EAGLEVIEW SUBDIVISION CONSTRUCTION DOCUMENTS

PCD FILE #: SF-22-42

EAGLEVIEW
EL PASO COUNTY, COLORADO
CONSTRUCTION DOCUMENTS
COVER SHEET

SHEET
C1.2

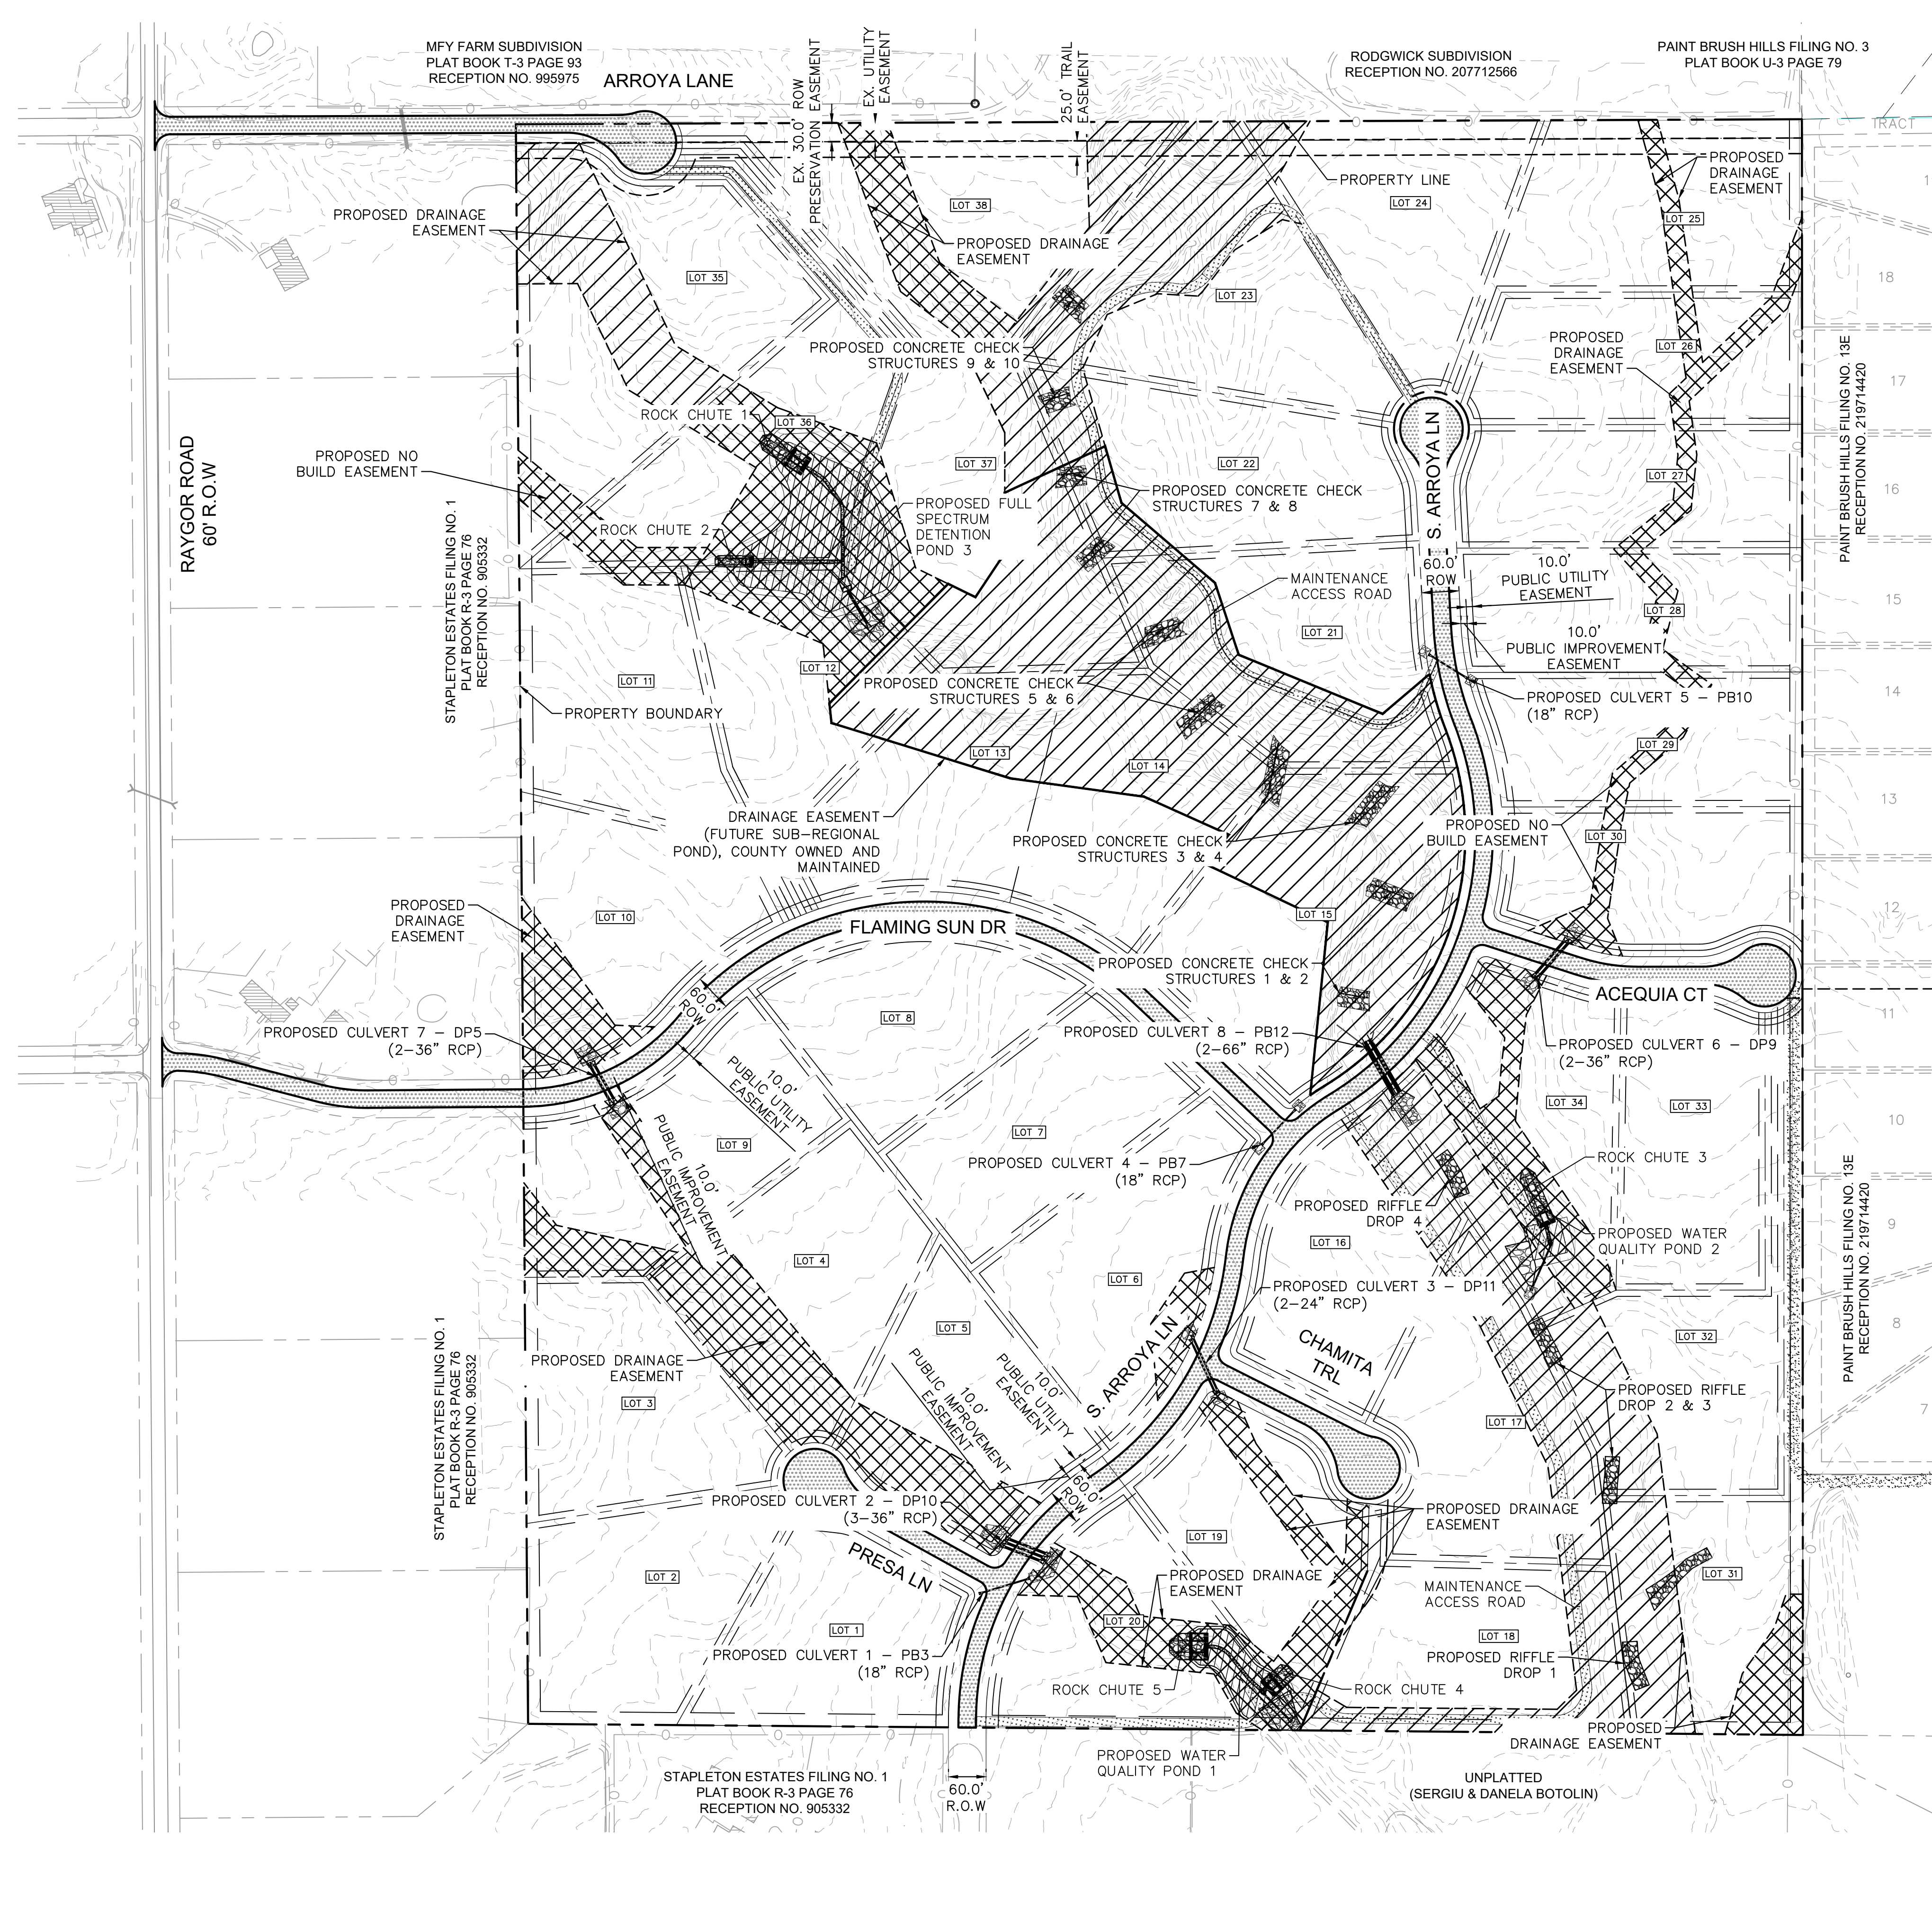
label as section F to match what is shown on sheet C1.18

please identify where these sections are located on the plans. It appears that the south channel section may be section H shown on the plans.

revise to 3.3.3.K as 6.5.3 does not exist

KH Response: This is labeled as (F) already.

KH Response: These sections are labeled in the grading plans and best seen in the south channel / check structure sheets. Additional notes added for clarification

KH Response: Updated

EAGLEVIEW EL PASO COUNTY, COLORADO CONSTRUCTION DOCUMENTS HORIZONTAL CONTROL PLAN

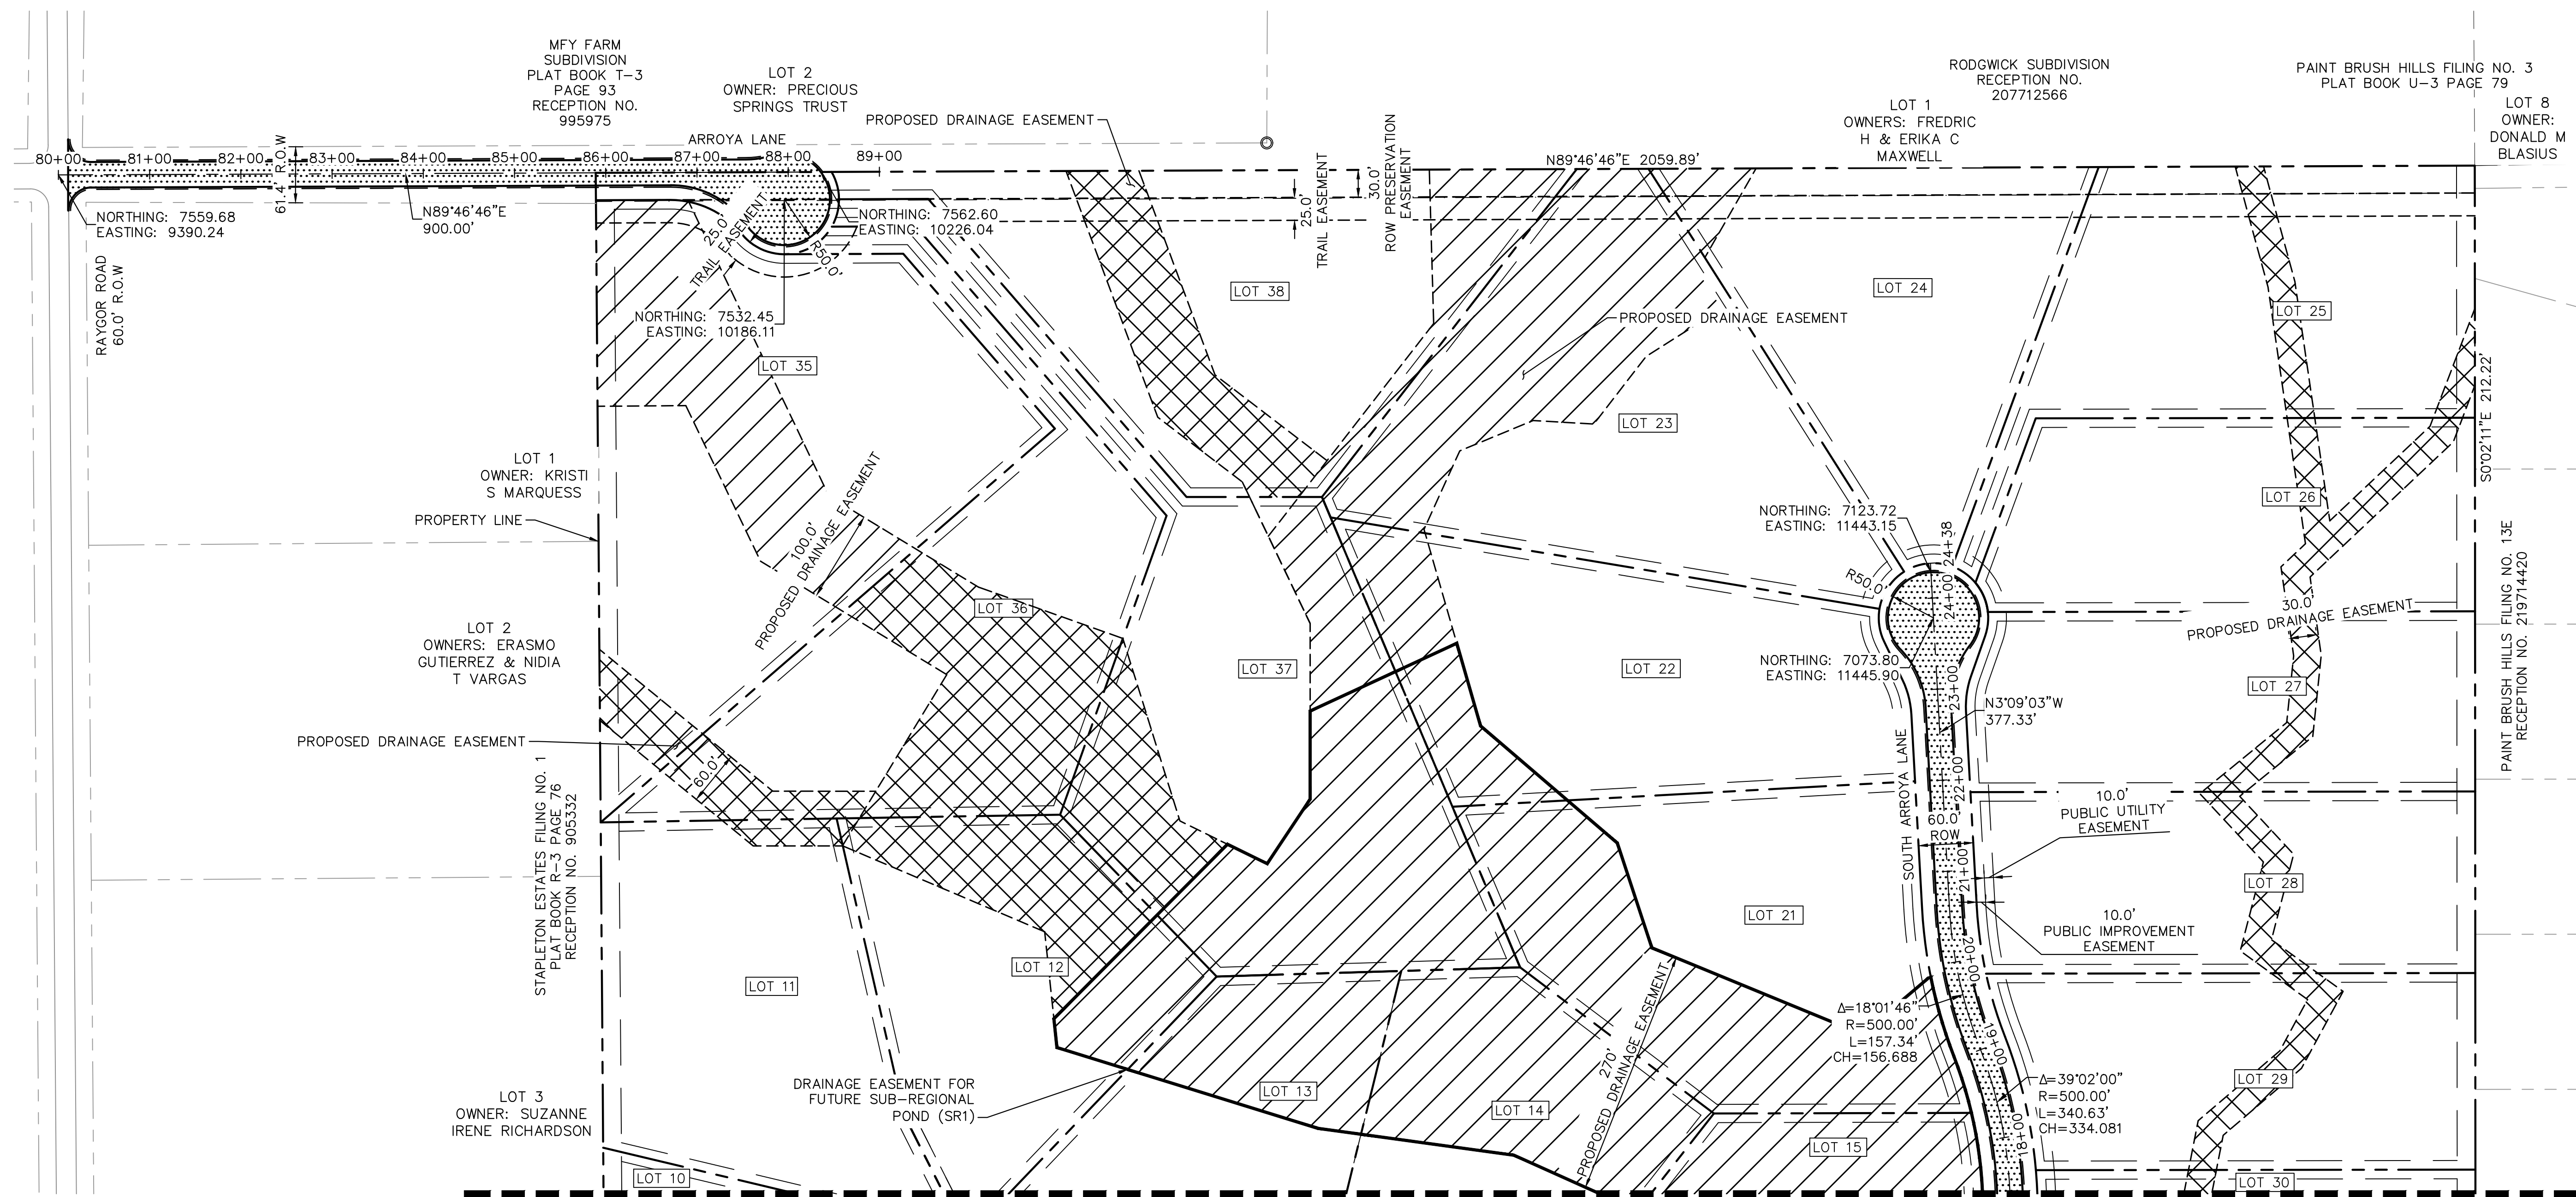
please add vegetation, TRM, and coir mat

KH Response: Updated
